Our reference: DOC16/153077; EF16/3005
Your reference: SSI 5118 MOD 1 DA 81-04-01 MOD 3
Contact: Jocelyn Karsten (02) 4908 6865

**REQUEST FOR COMMENTS ON MARINE FINFISH RESEARCH & COMMERCIAL
AQUACULTURE PROVIDENCE BAY
(SSI 5118 MOD 1 AND DA 81-04-01 MOD 3)**

Reference is made to your request dated 8 March 2016, for the Environment Protection Authority (EPA) to provide comments on the modification request and Environmental Assessment for the Marine Finfish Research & Commercial Aquaculture Providence Bay Project (SSI 5118 MOD 1 and DA 81-04-01 MOD 3).

Figure 4: Proposed sea pen layout at each site (viewed from top)

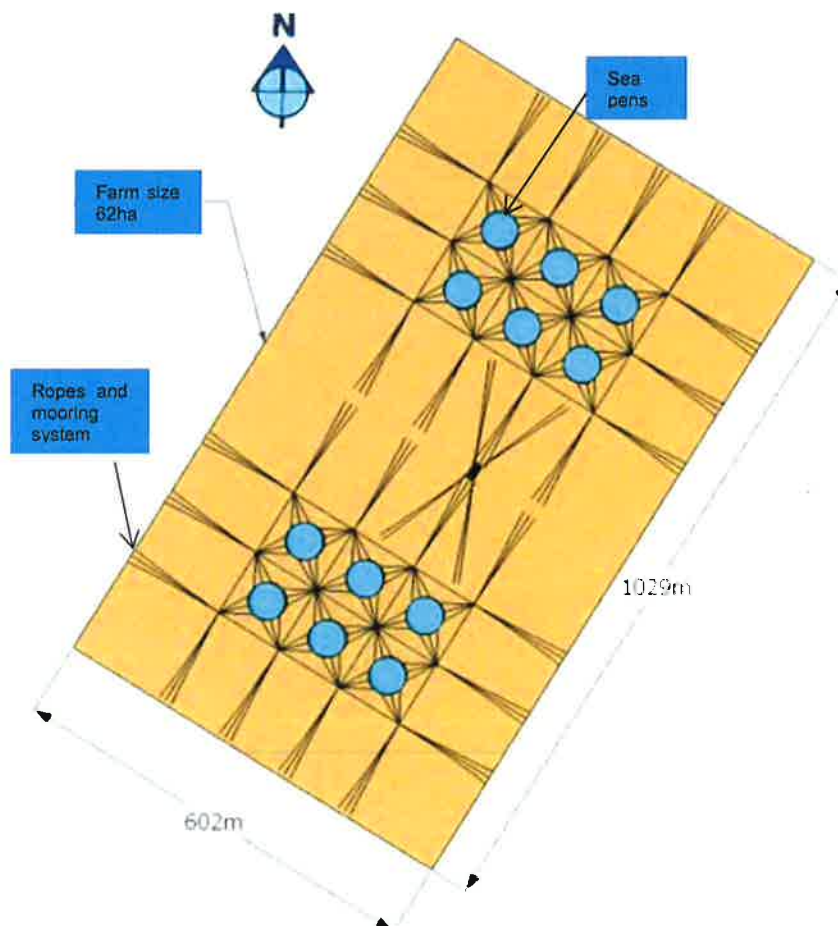
There is no assessment of the impacts of the anchoring system on the seafloor. Impacts may be minimal if the seabed is soft sediment. This needs to be discussed in the assessment report. The EPA was unsure whether the new sea pens will have a different anchoring system to the existing pens and therefore whether they may have a different impact on the seafloor community at the new site within this habitat protection zone.
